Tel: 01903 737756
Email: planning@arun.gov.uk
www.arun.gov.uk/planning
Please ask for: Breezie Allwright
Email: breezie.allwright@arun.gov.uk
Telephone: 01903 737500
Our Ref: FG/27/26/PDH
Your Ref:
Date: 20th April 2026

Prior Notification for a Permitted Development (Householder)

Development: Notification under extended permitted development rights for proposed single storey extension to rear of existing detached bungalow and changes to fenestration.
Location: 116 Littlehampton Road Ferring BN12 6PL

Drawing	
Proposed elevations	
Issue Date 11.03.2026	CHL drawing ref. 2026-14-03c
Scale 1:100@A3

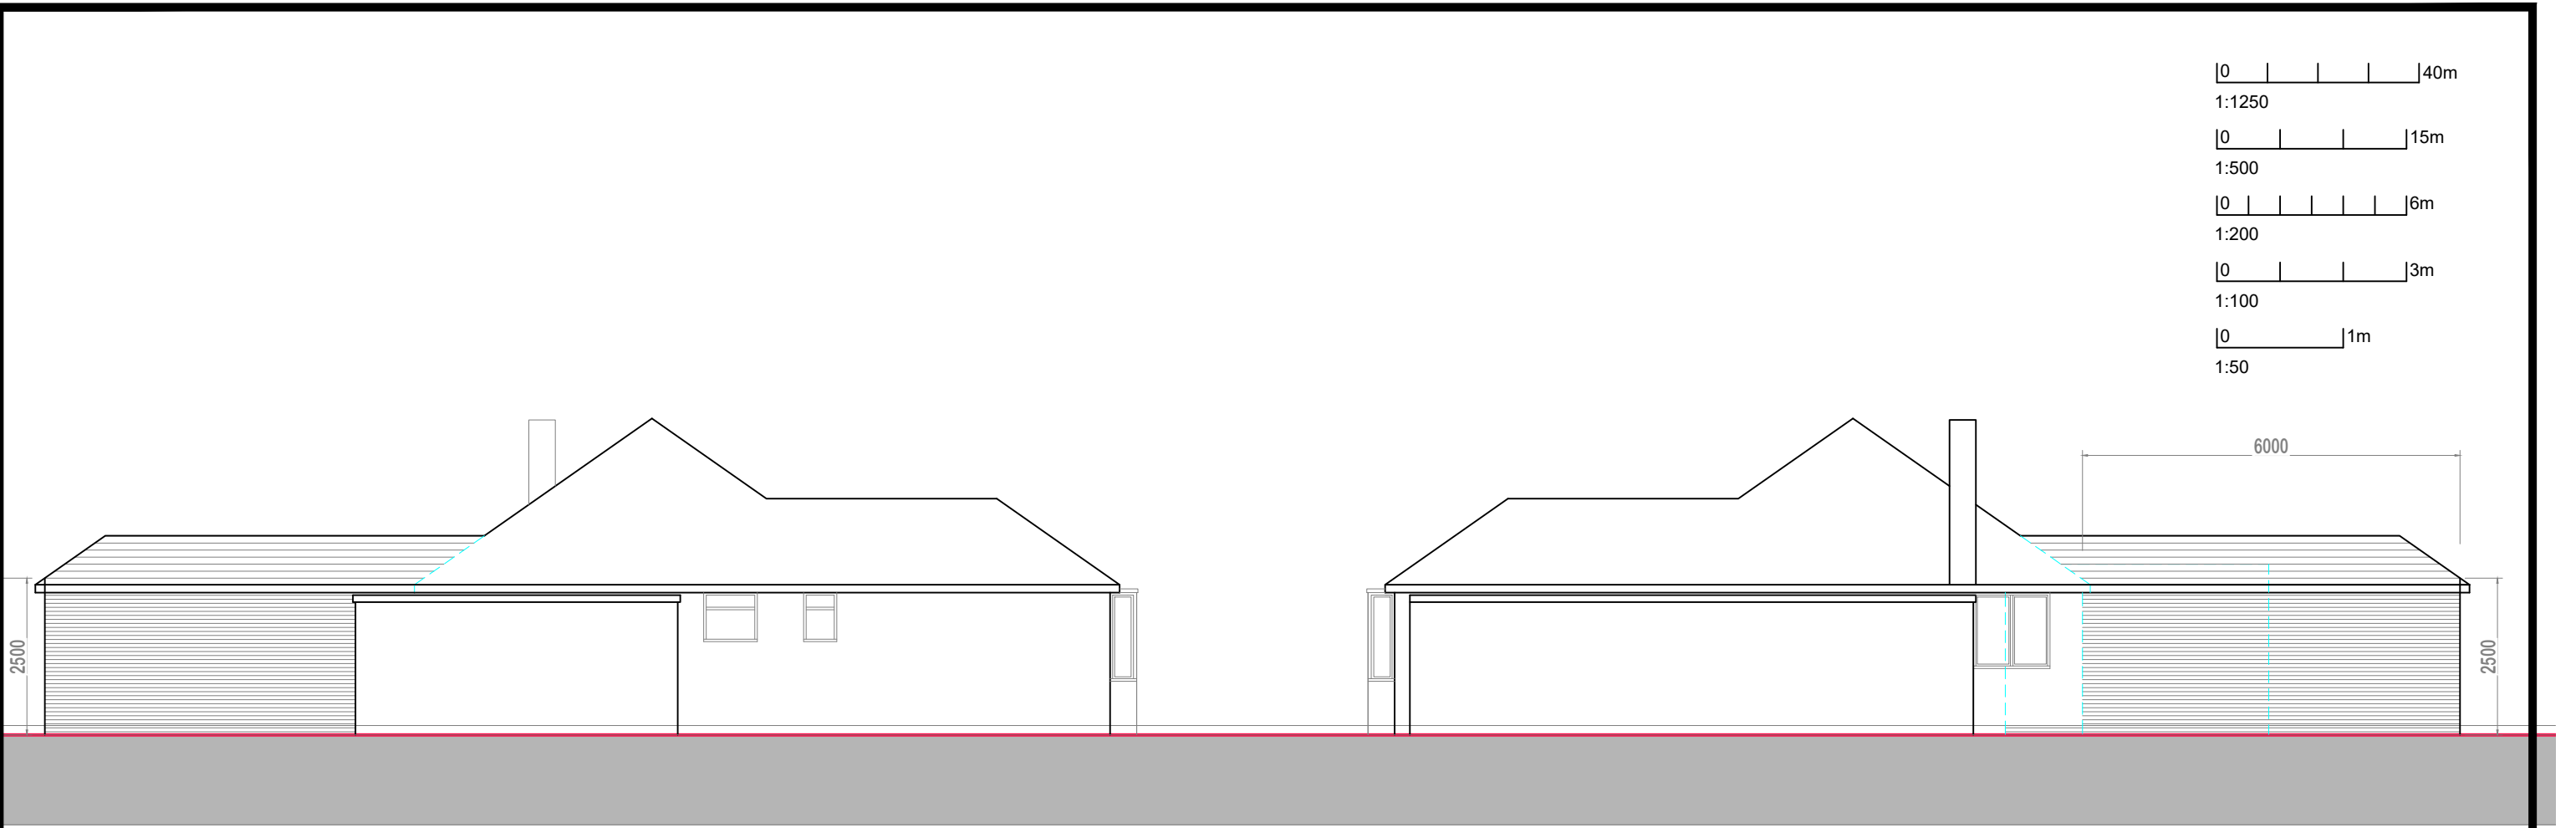
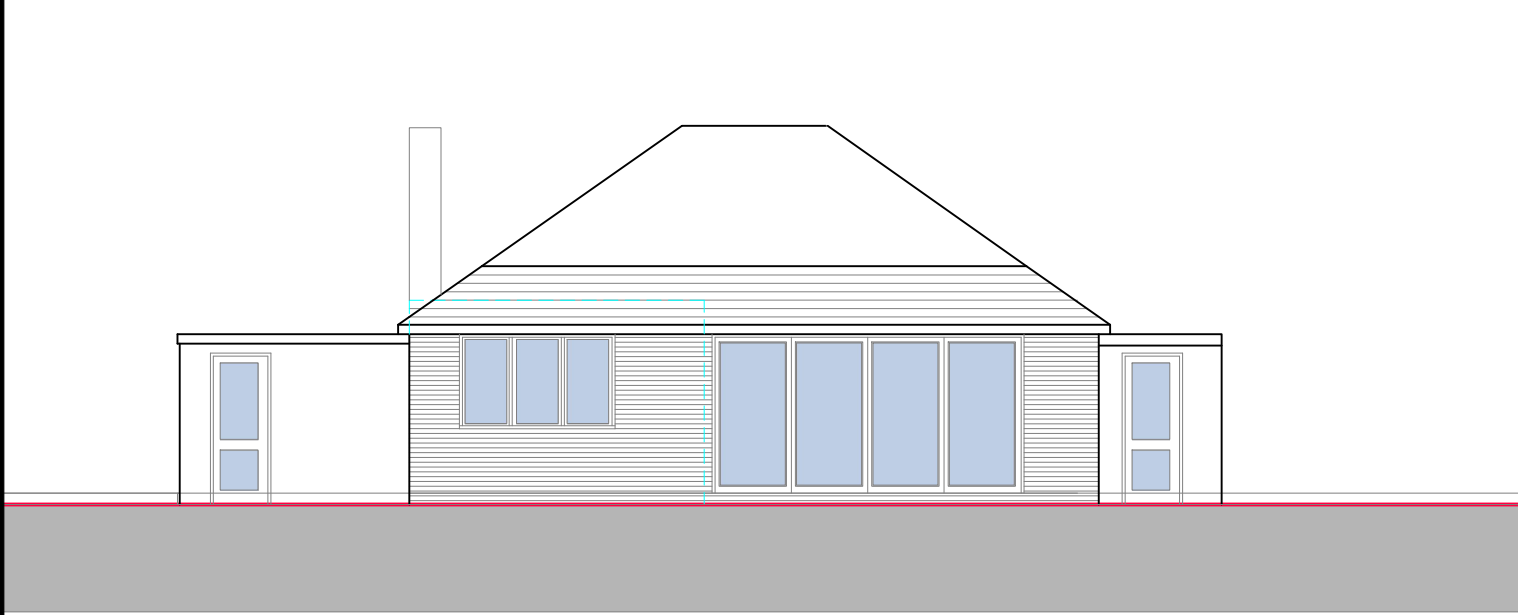
The eaves height on the form is listed as 2.60 m but the drawings show an eaves height of 2.20m. Please amend accordingly.
